Date: 12 March 2024

Application by Gatwick Airport Limited for an Order Granting Development Consent for the Gatwick Airport Northern Runway Project

Tunbridge Wells Borough Written Representation (unique reference number 20041435)

Centre OS Grid Reference: E:527310, N:140941

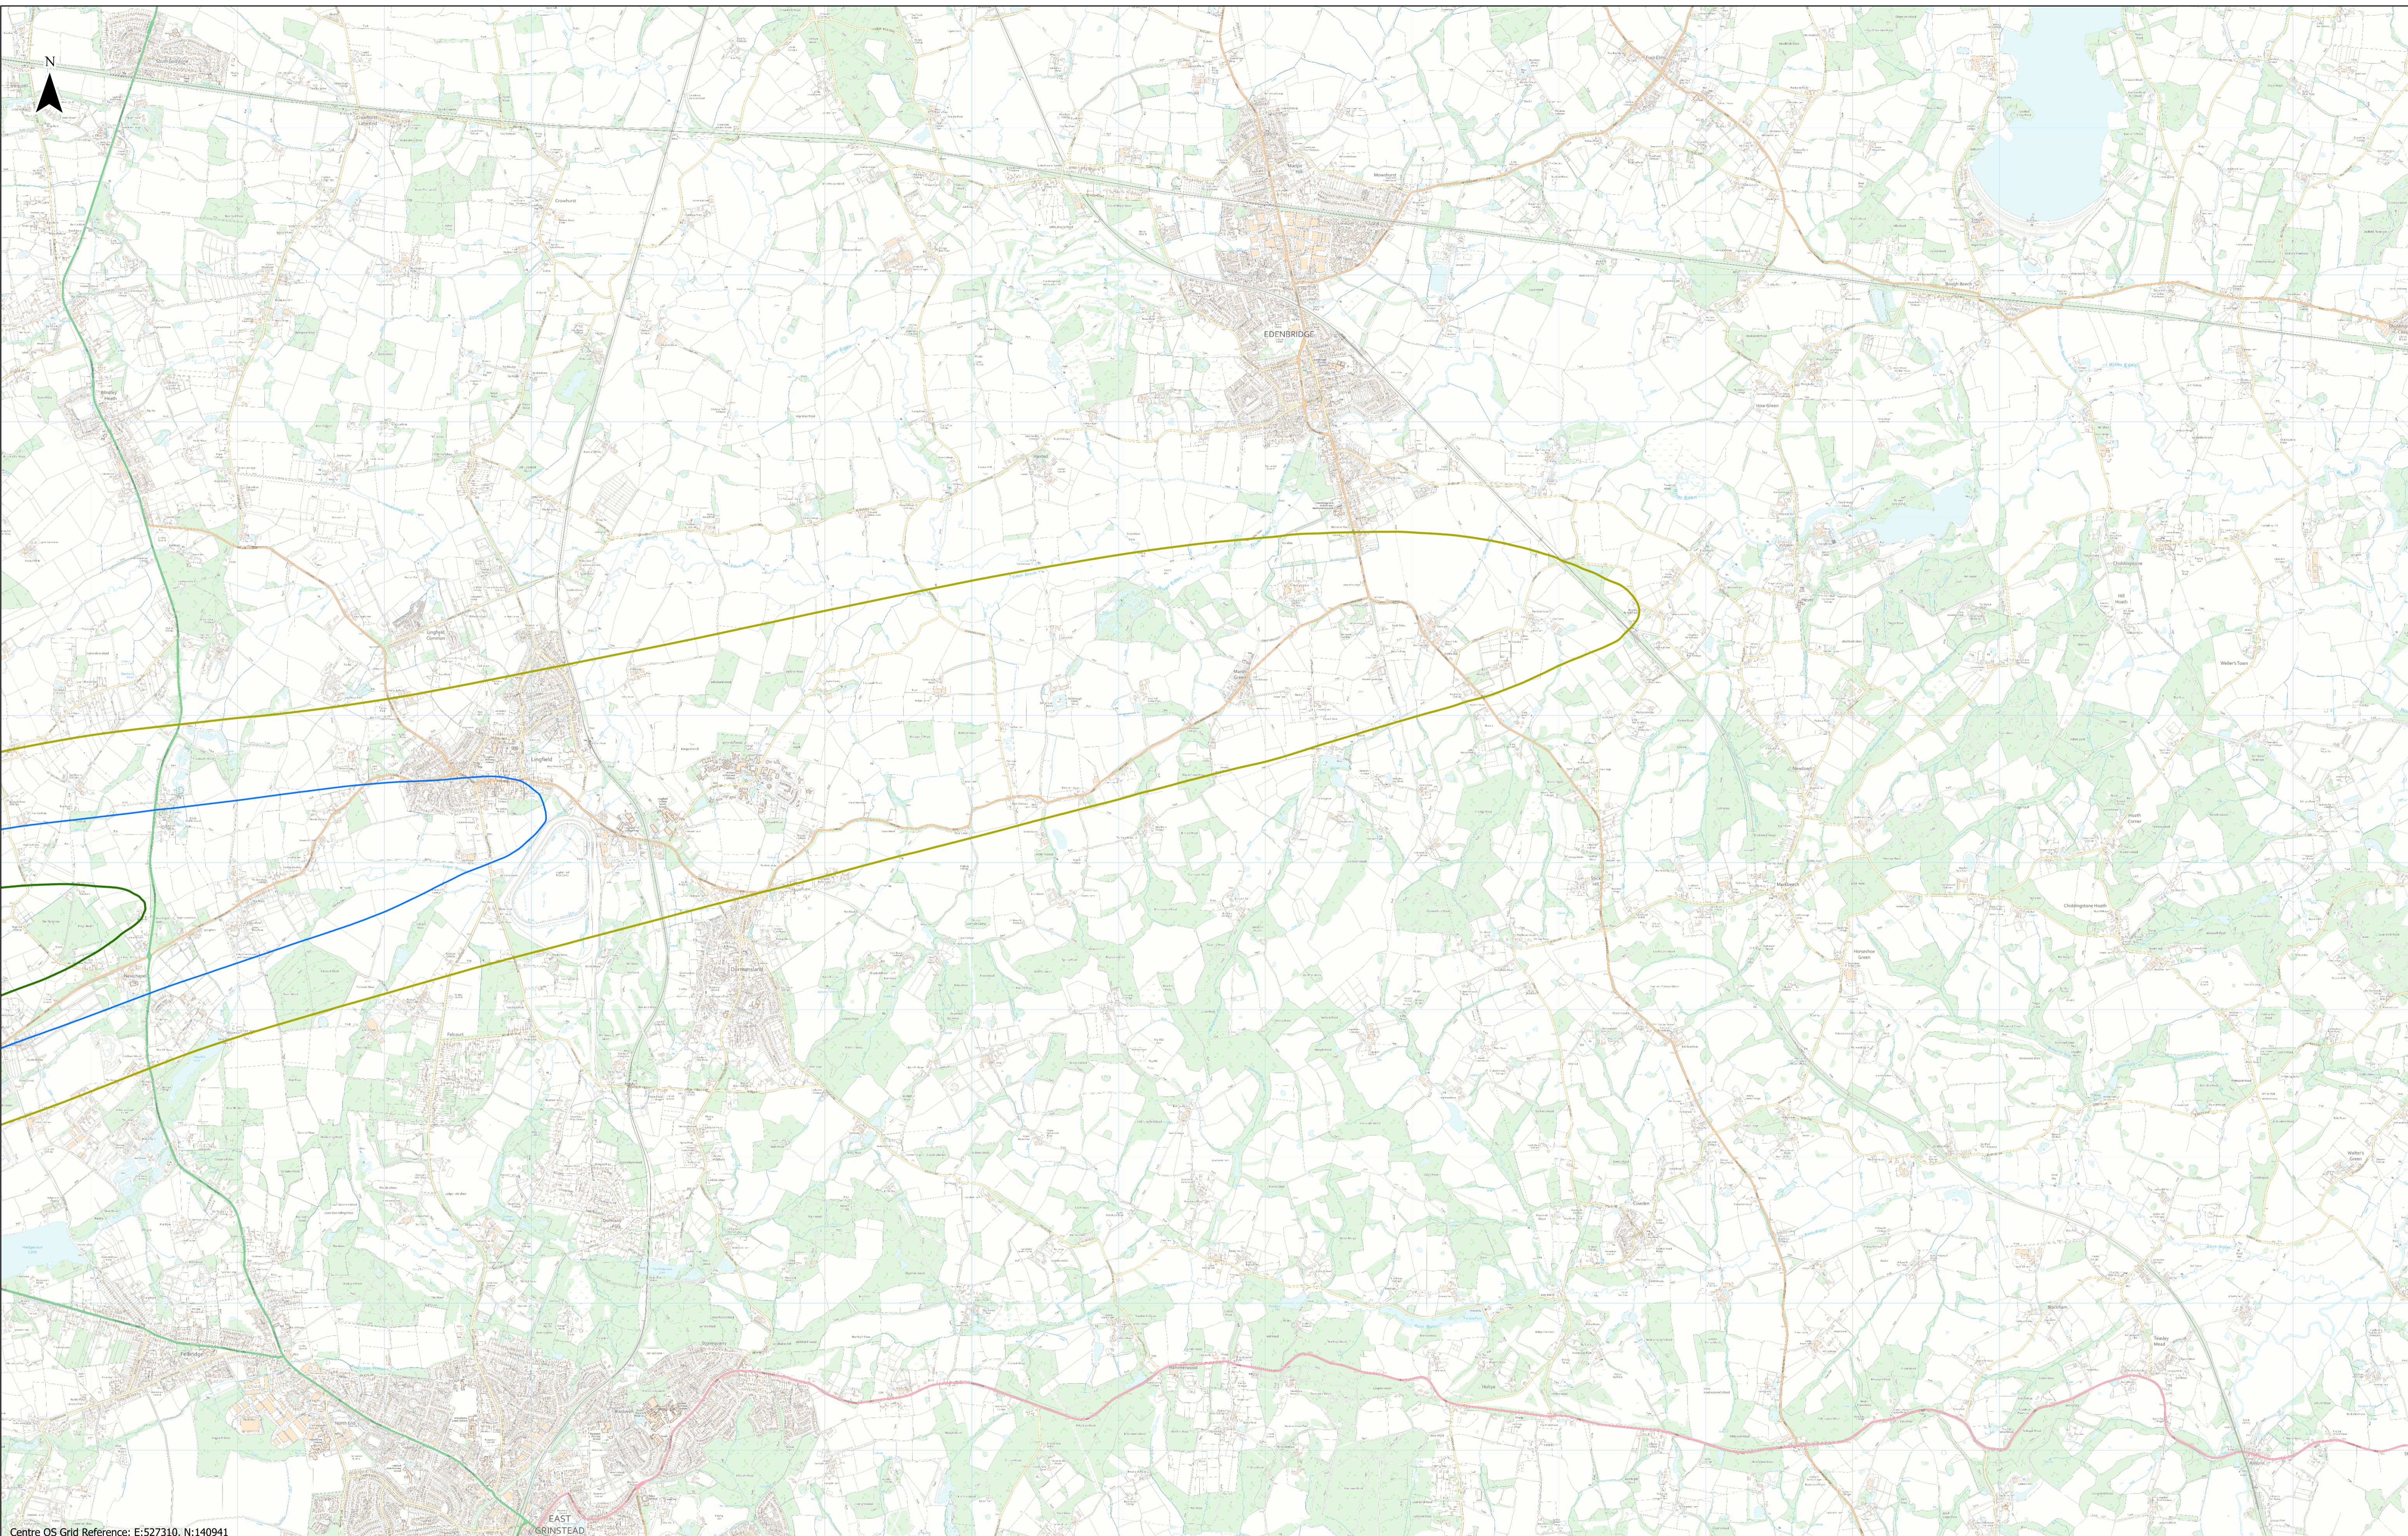
Currently the Applicant's Noise Insulation Scheme [APP-180] document provides a small-scale map of the proposed boundaries. Given Kent's distance from the airport, it is likely any eligible households will be located within the Outer Zone but it is difficult to determine from the size of the map exactly where the boundary will fall. In addition, information should be provided around which schools would be included within the Schools Insulation Scheme, along with details of other noise sensitive receptors.
